From: Sue Howell
Sent: 12 June 2017 14:44
To: Planning.Responses
Cc: Anita Gardner
Subject: RE: Planning Consultation on A/64/17/DOC

Comment from Greenspace

APPLICATION **A/64/17/DOC**
NO:

Registered: 06-APR-17
Site Address: Land R/O 1 - 6 The Cottrells Angmering

Rev	Description	Date
Job Reference		Client
New House The Cottrells Angmering		AM Homes Ltd
Drawing Title		Drawing No
Hard & Soft Landscaping Plan		AD962/02
Date	Scale	Dwg Size
26.02.17	1:100	A3
Plot Style	Drawn	Checked
ADG/ryc/sk	TGG	AD

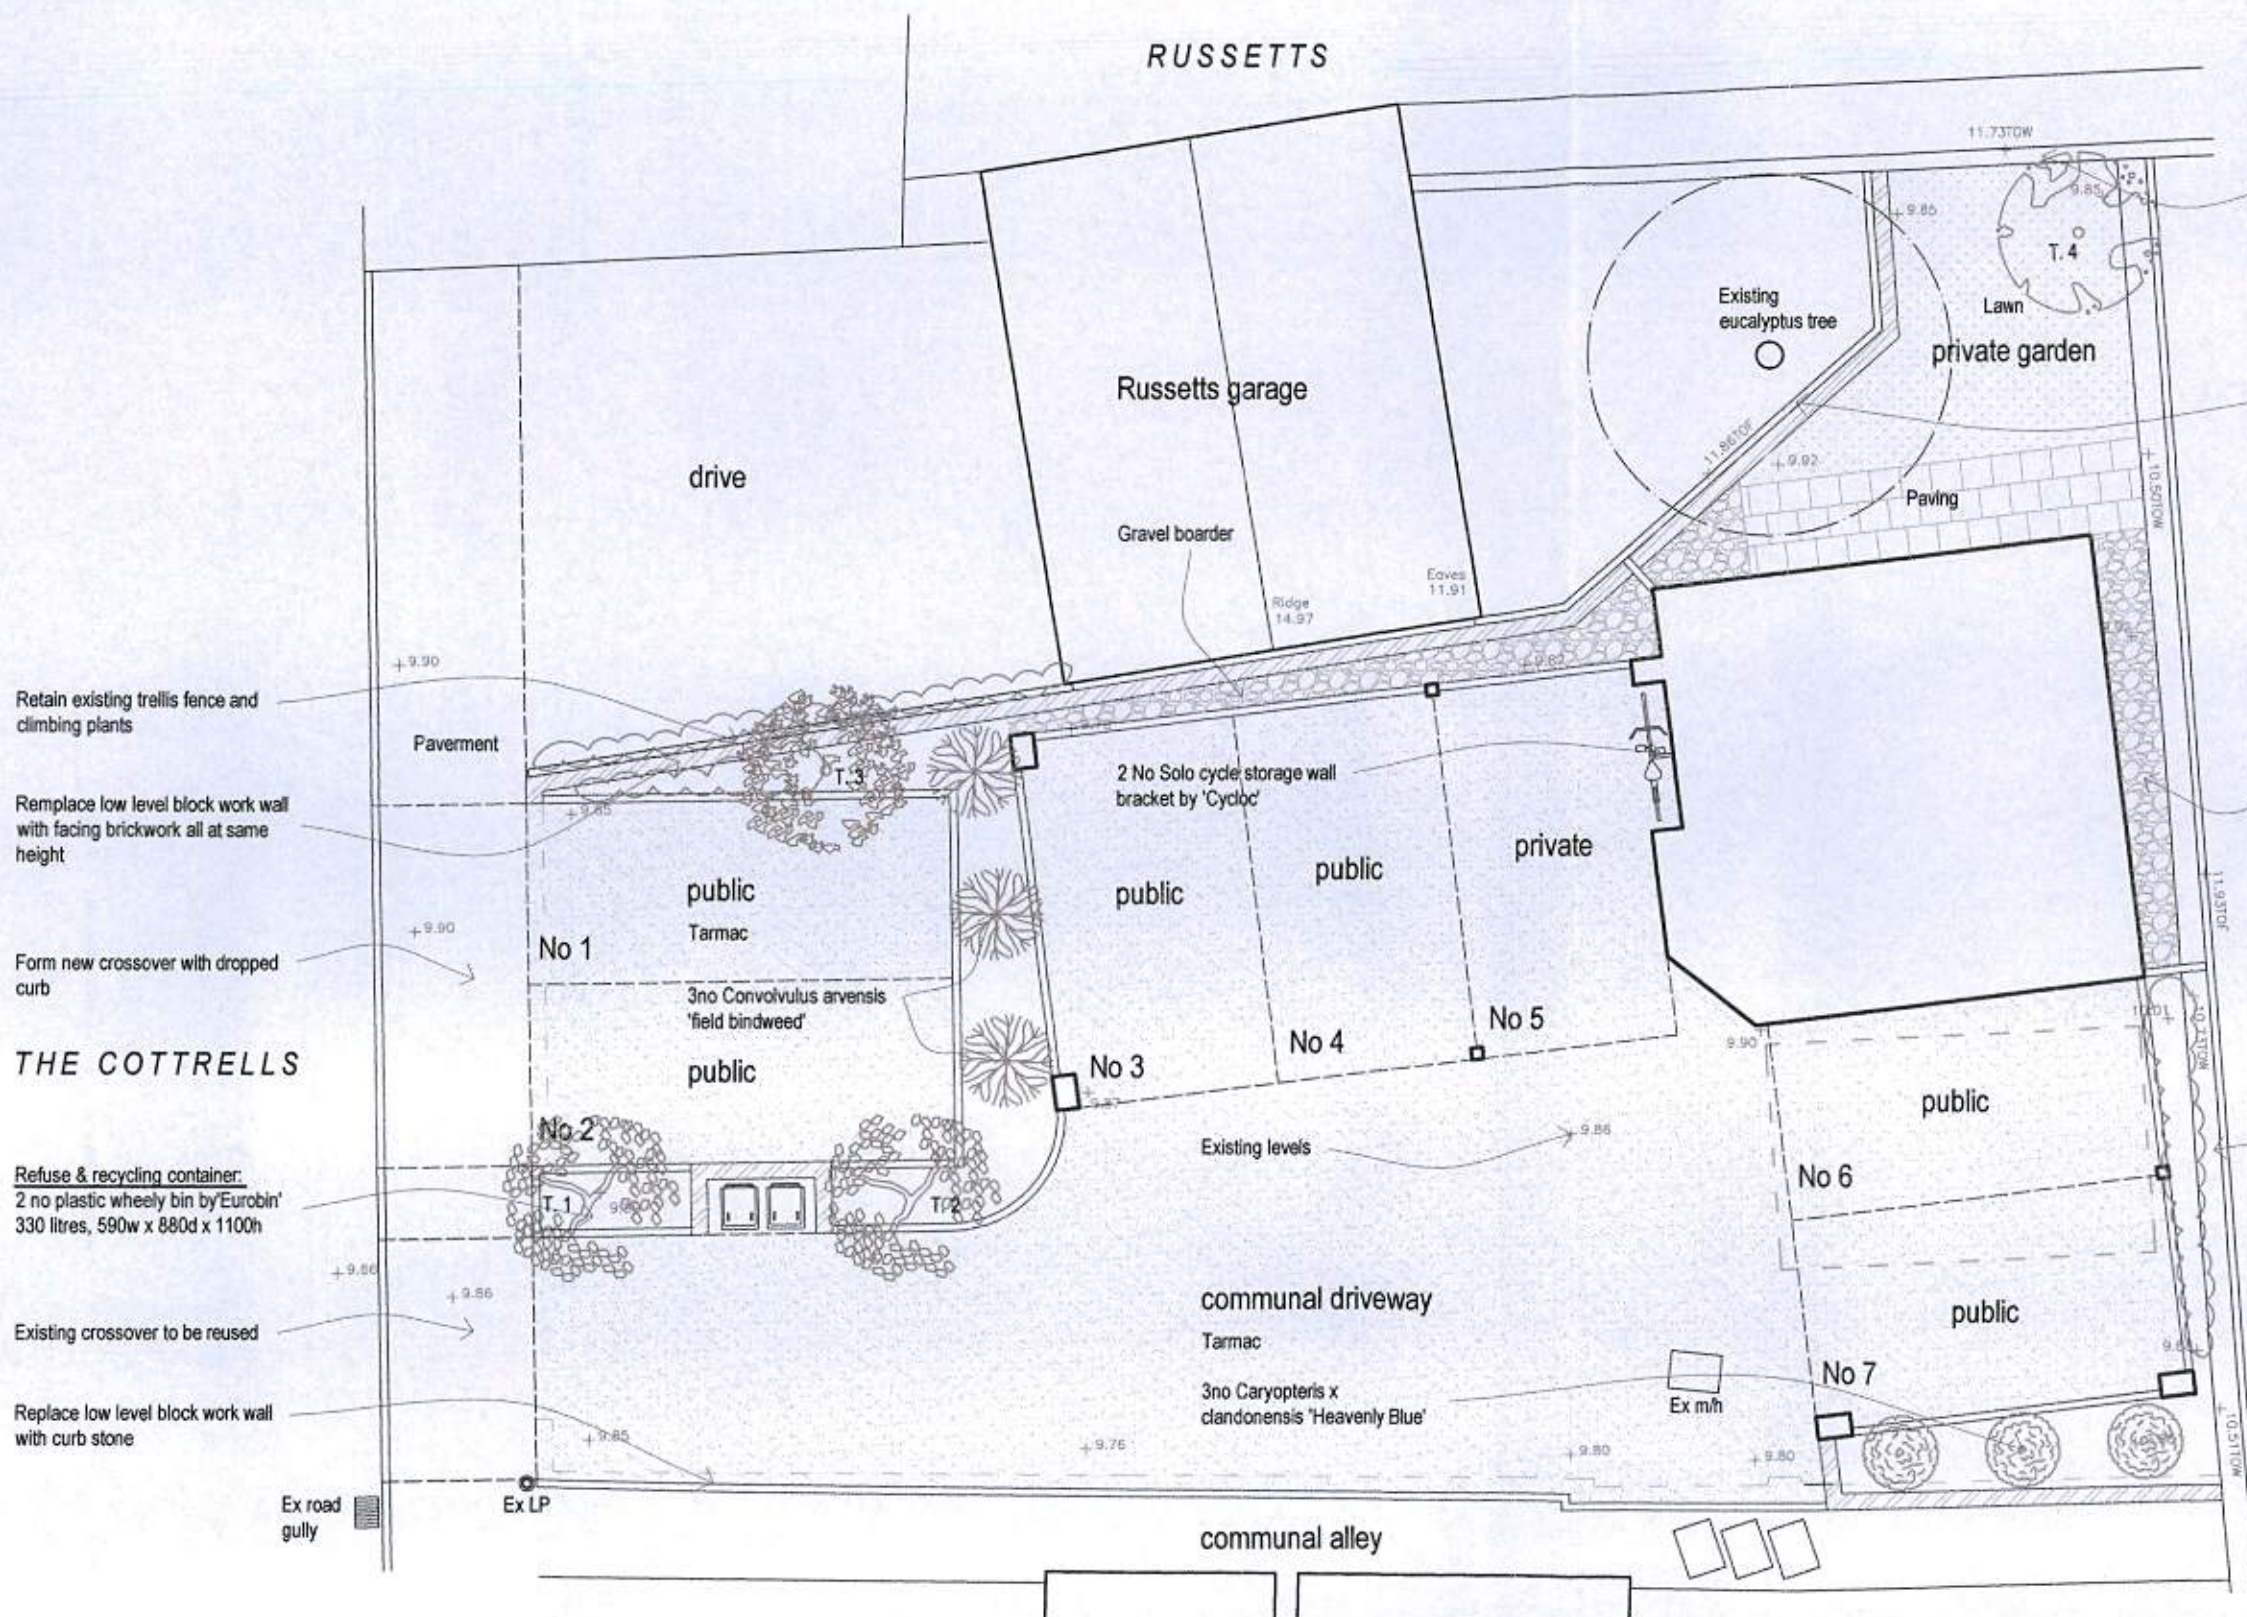
Further to submission of dwg No AD/962/02 Rev A, I can confirm that the information now provided is suitable for location and sufficient in detail, to now recommend the discharge of Landscape Condition 9 of application A/64/17/DOC imposed under A/173/16/PL.
